2190460

## Response to Submissions

### 89 John Whiteway Drive, Gosford – SSD 10362

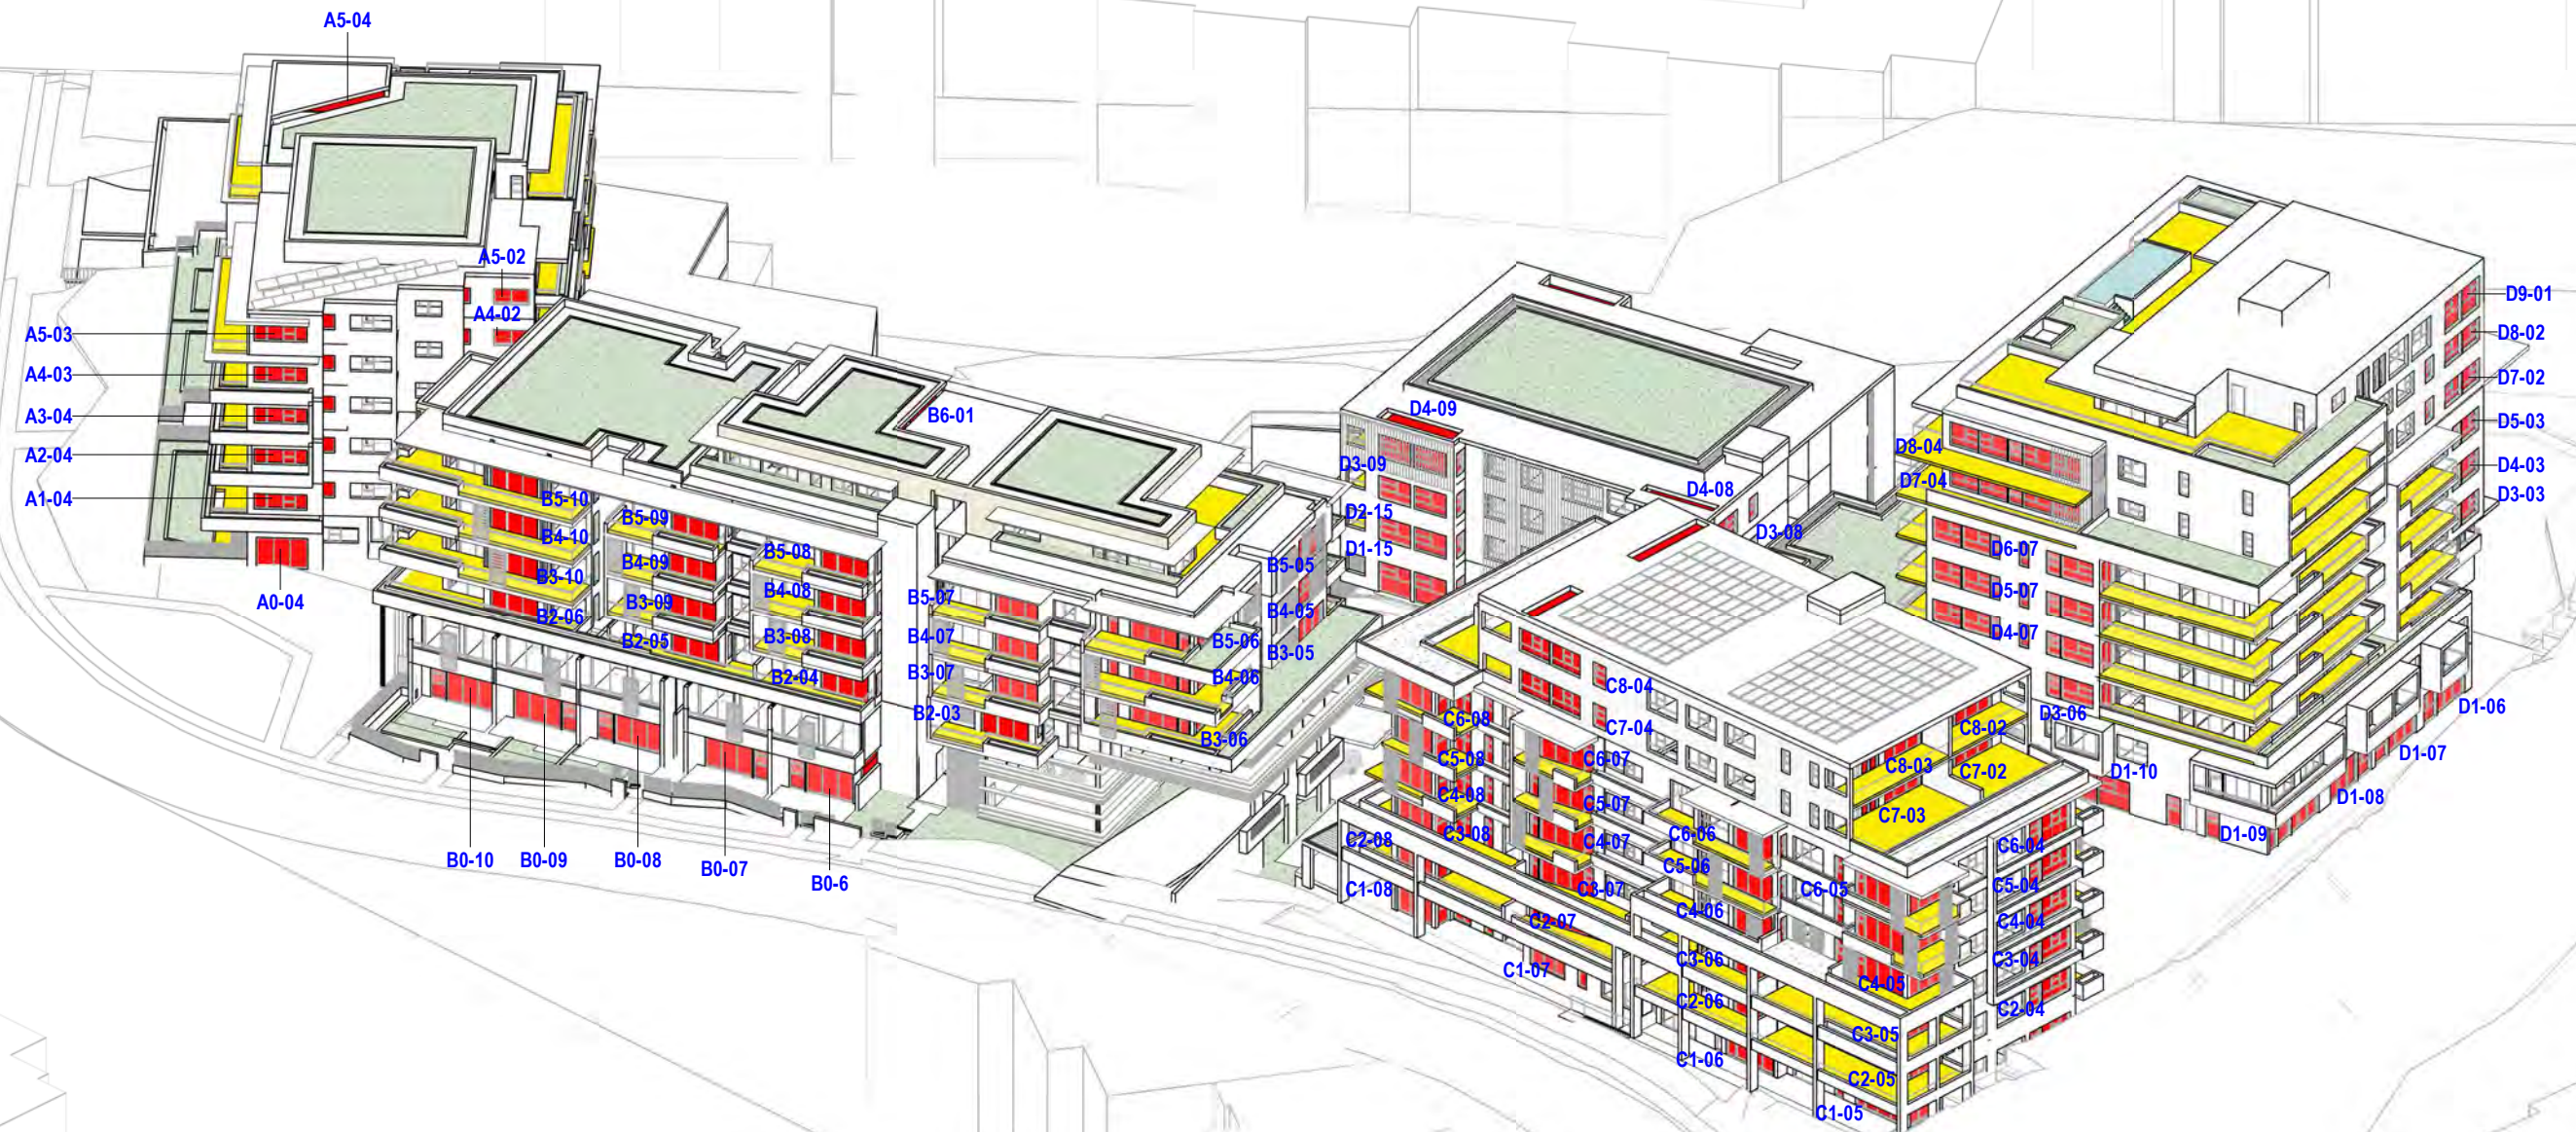
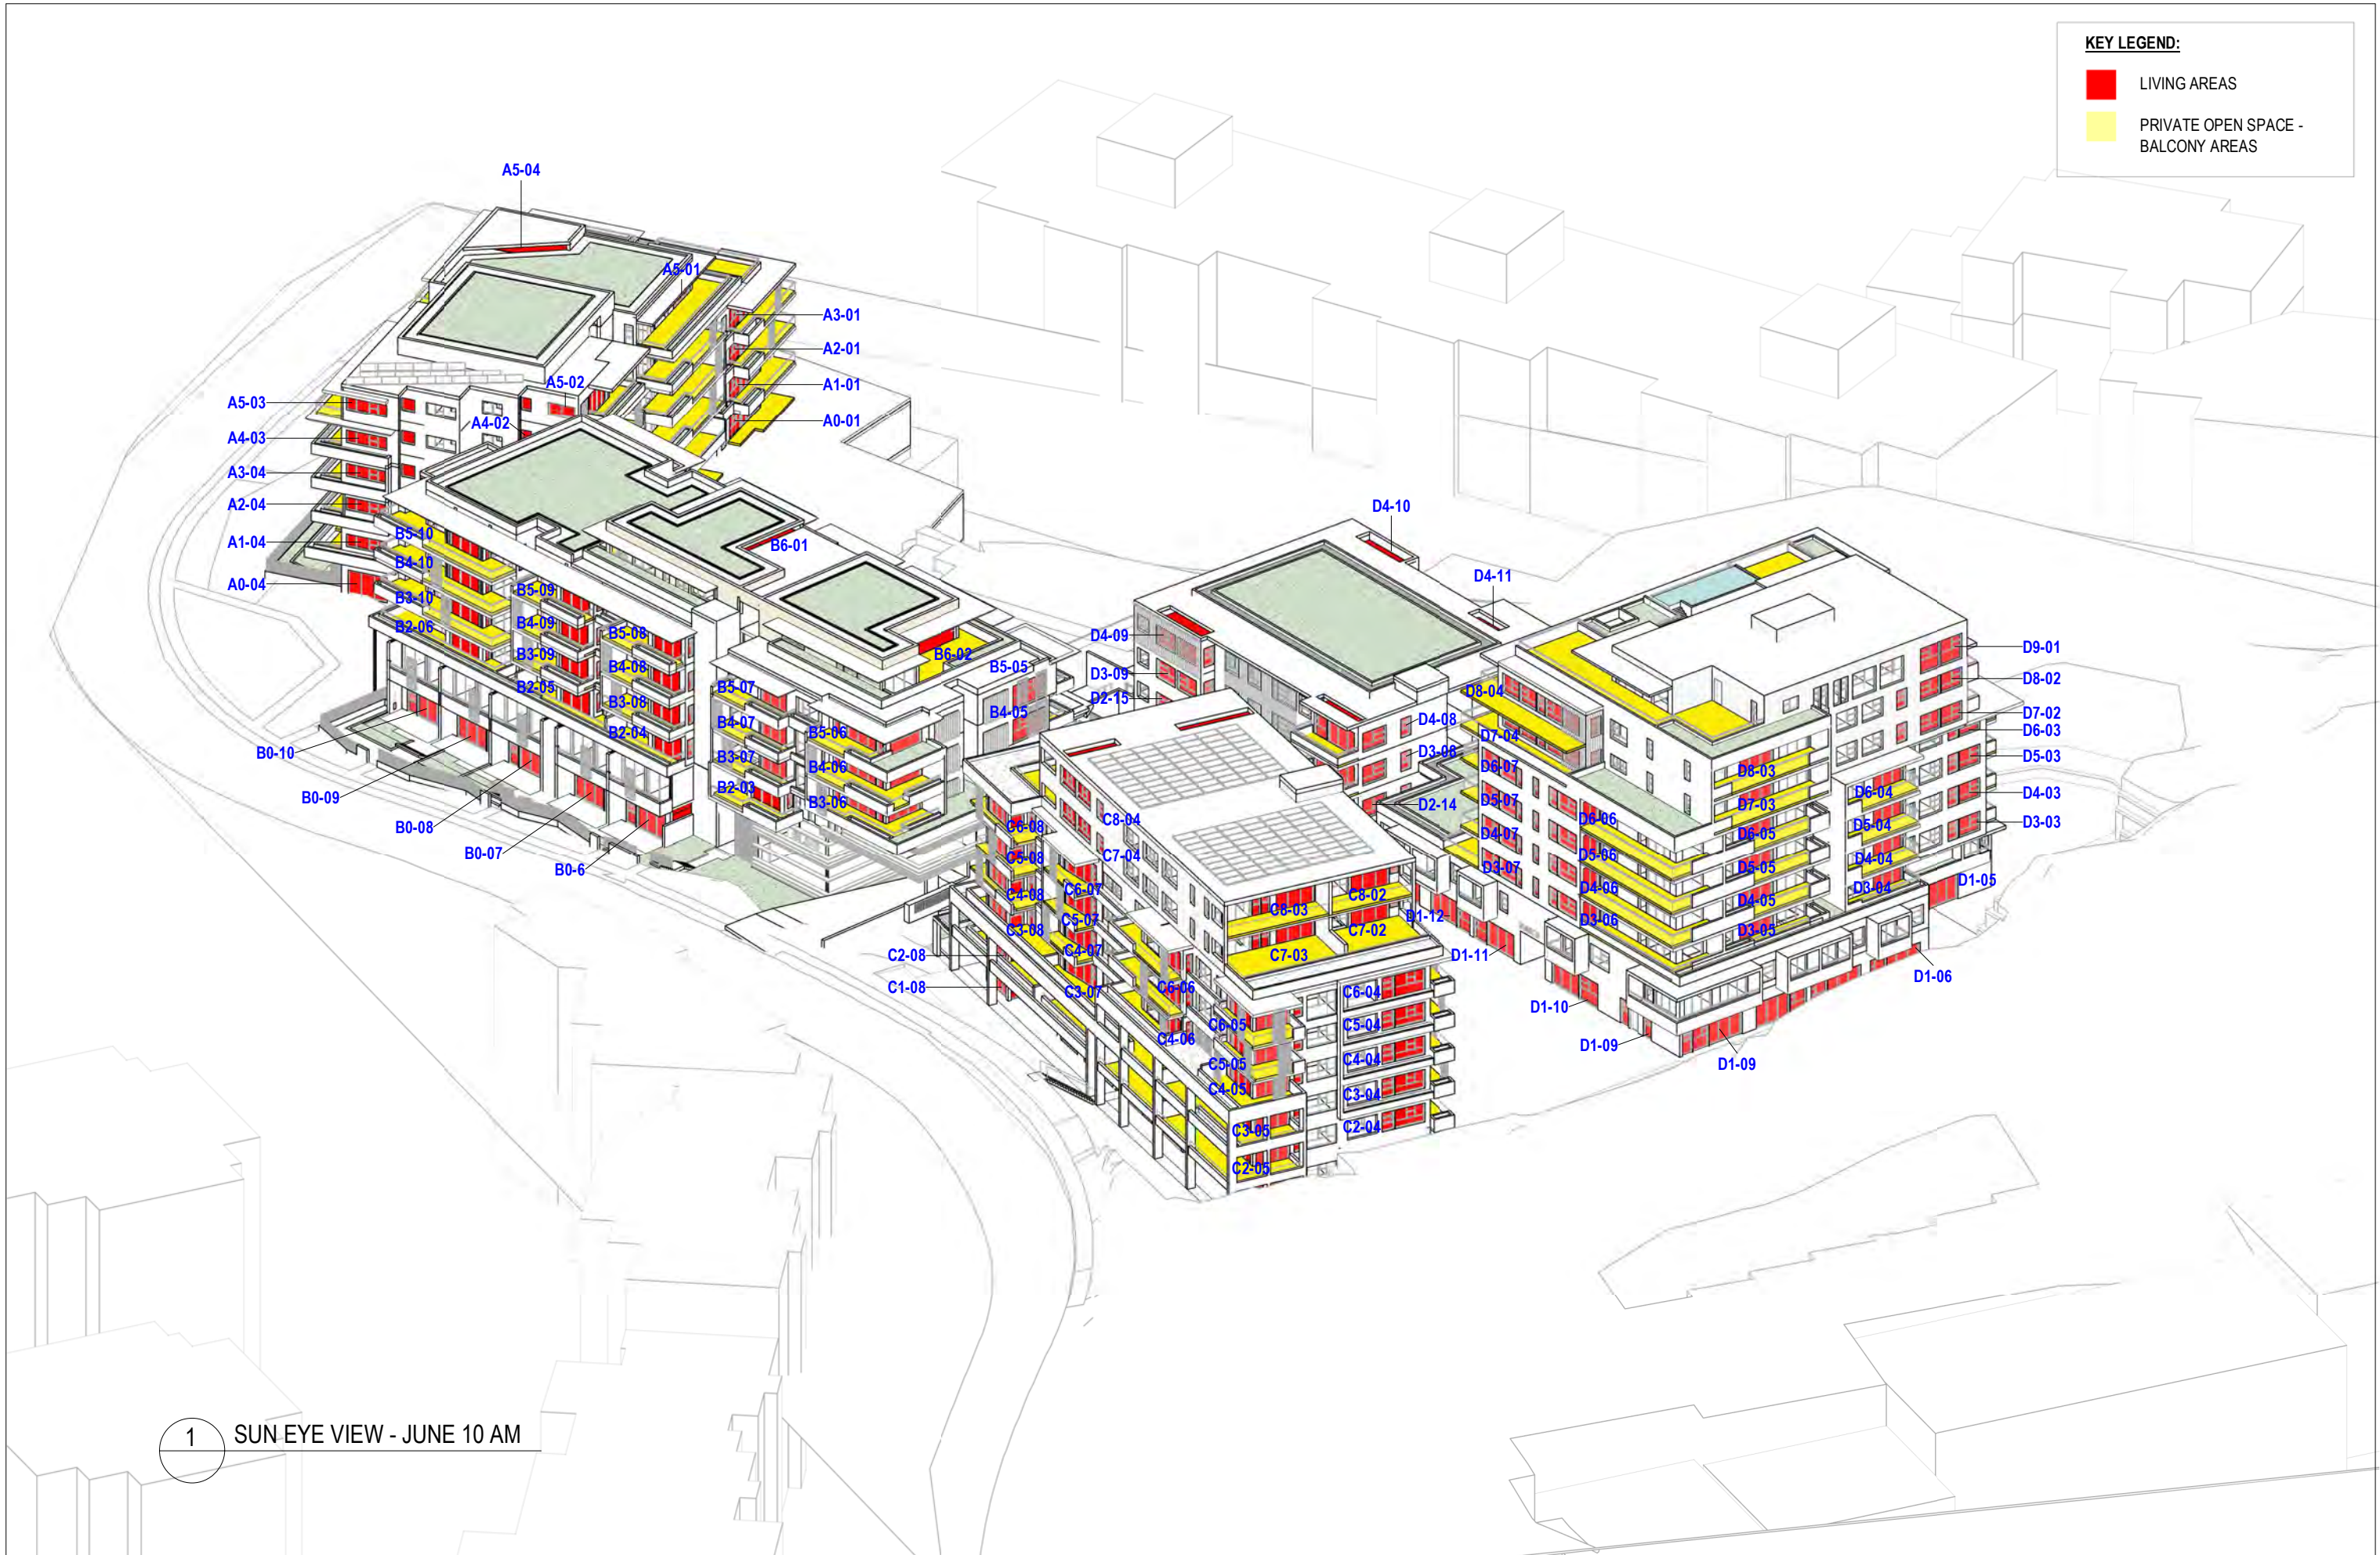
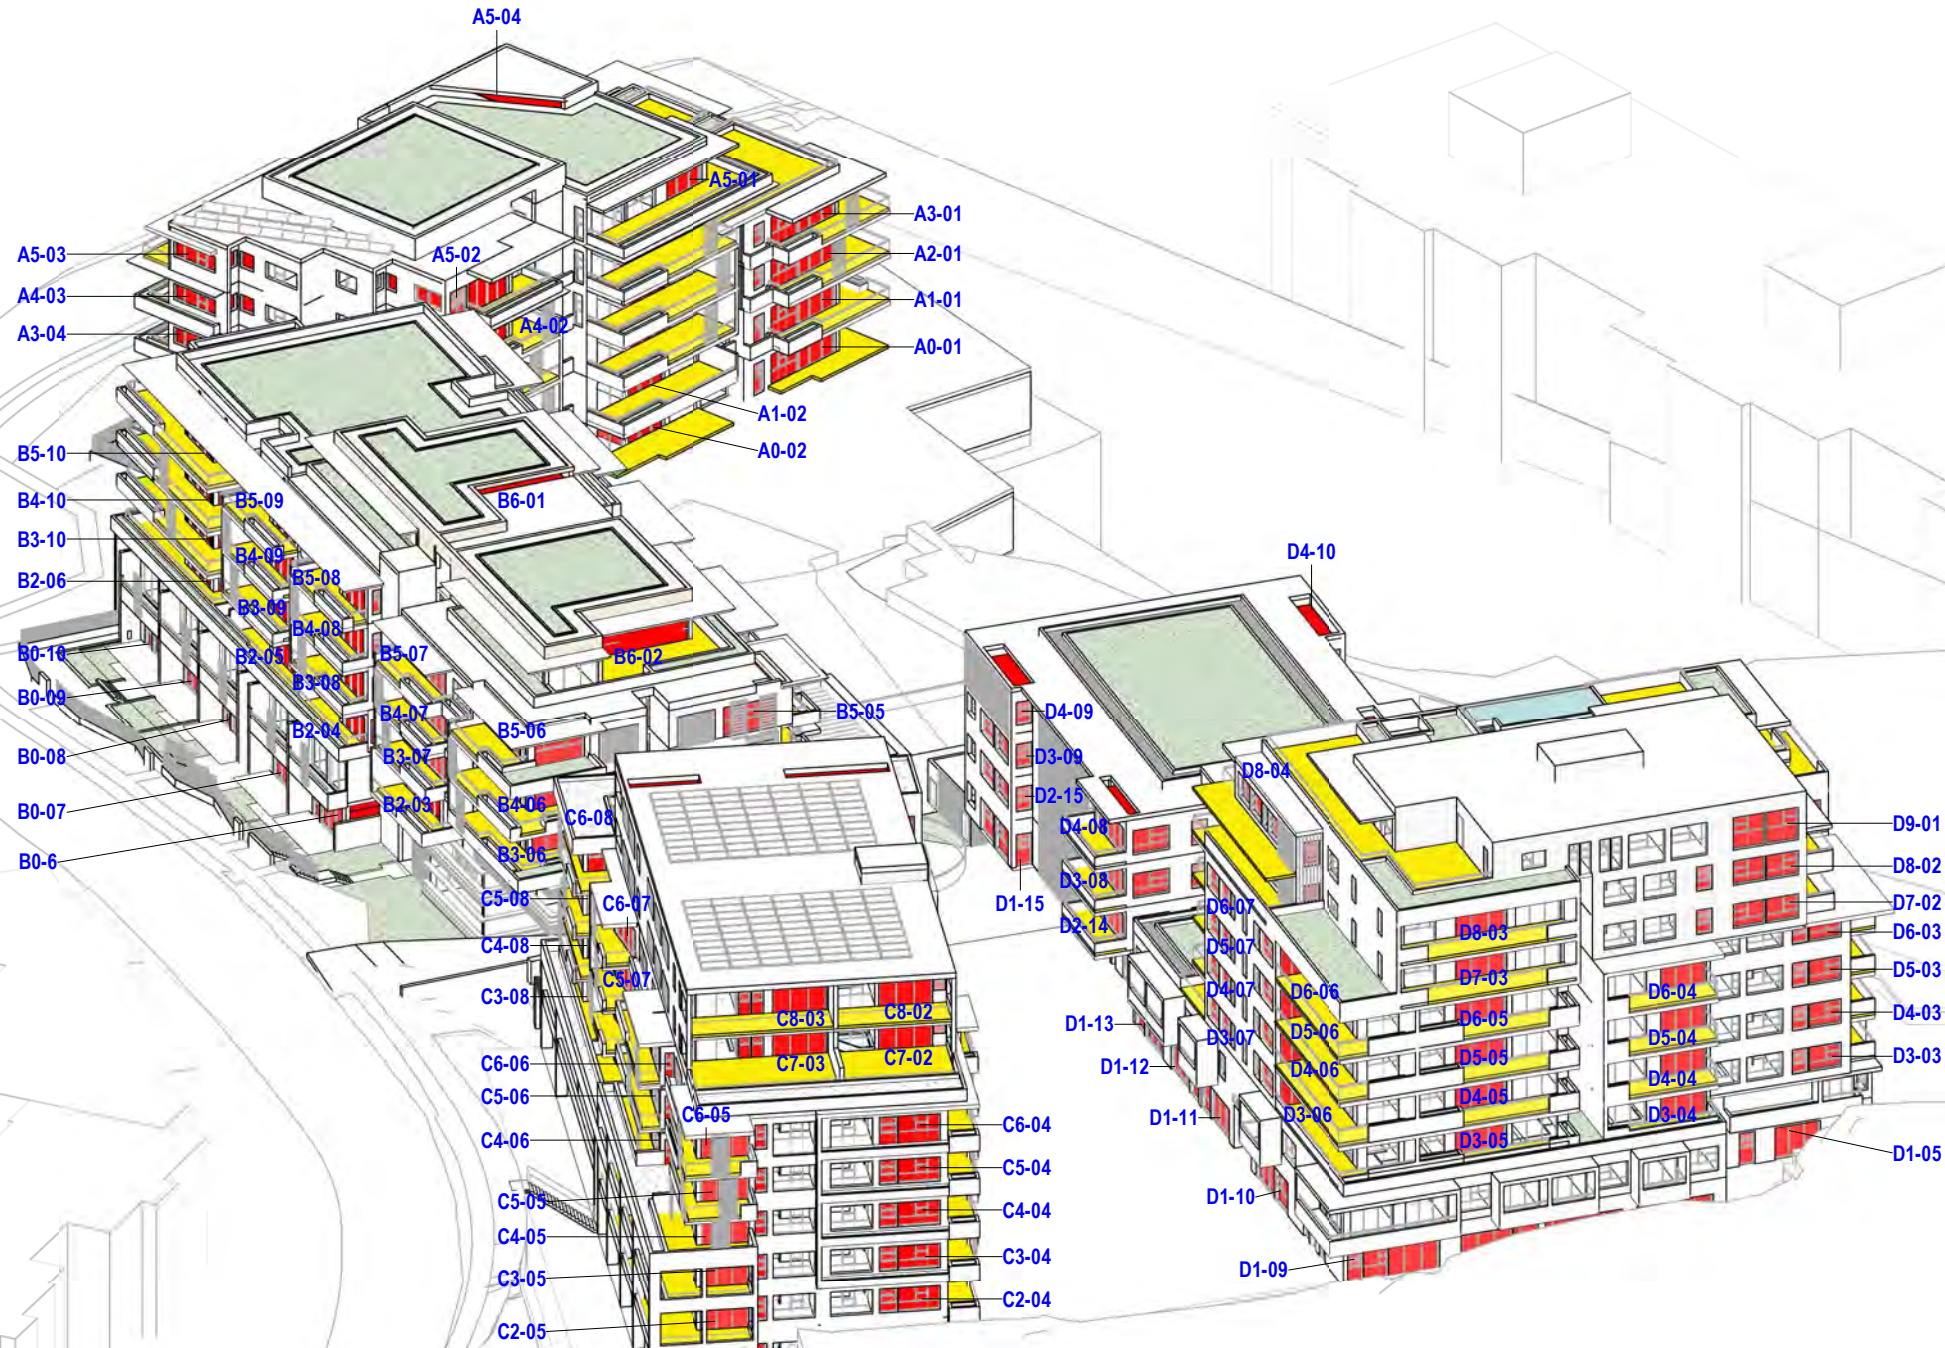
Comment	Comment
<b>Department of Planning, Industry and Environment</b>	
<p><b>Solar and daylight access</b> Please provide amended sun eye diagrams to clearly indicate where the living spaces and balconies are located. This information is required to allow cross reference between the solar access/overshadowing floor plan diagrams, summary schedules and the view from the sun.</p>	<p>New Sun Eye diagrams that are zoomed in with additional notated details are provided.</p>
<p>Please include elevation plans in the overshadowing analysis indicating the location of habitable rooms and private open space.</p>	<p>The Sun Eye Diagrams provide these details.</p>
<p>Please indicate the 40 units which will not receive 3 hours of sunlight but will have water views.</p>	<p>See Architectural Plan DA006.7D- DA006.7F</p>
<p>Please identify the units that receive 3 hours of sunlight to provide a complete understanding of the variation proposed.</p>	<p>See Architectural Plan DA006.7G- DA006.7I</p>
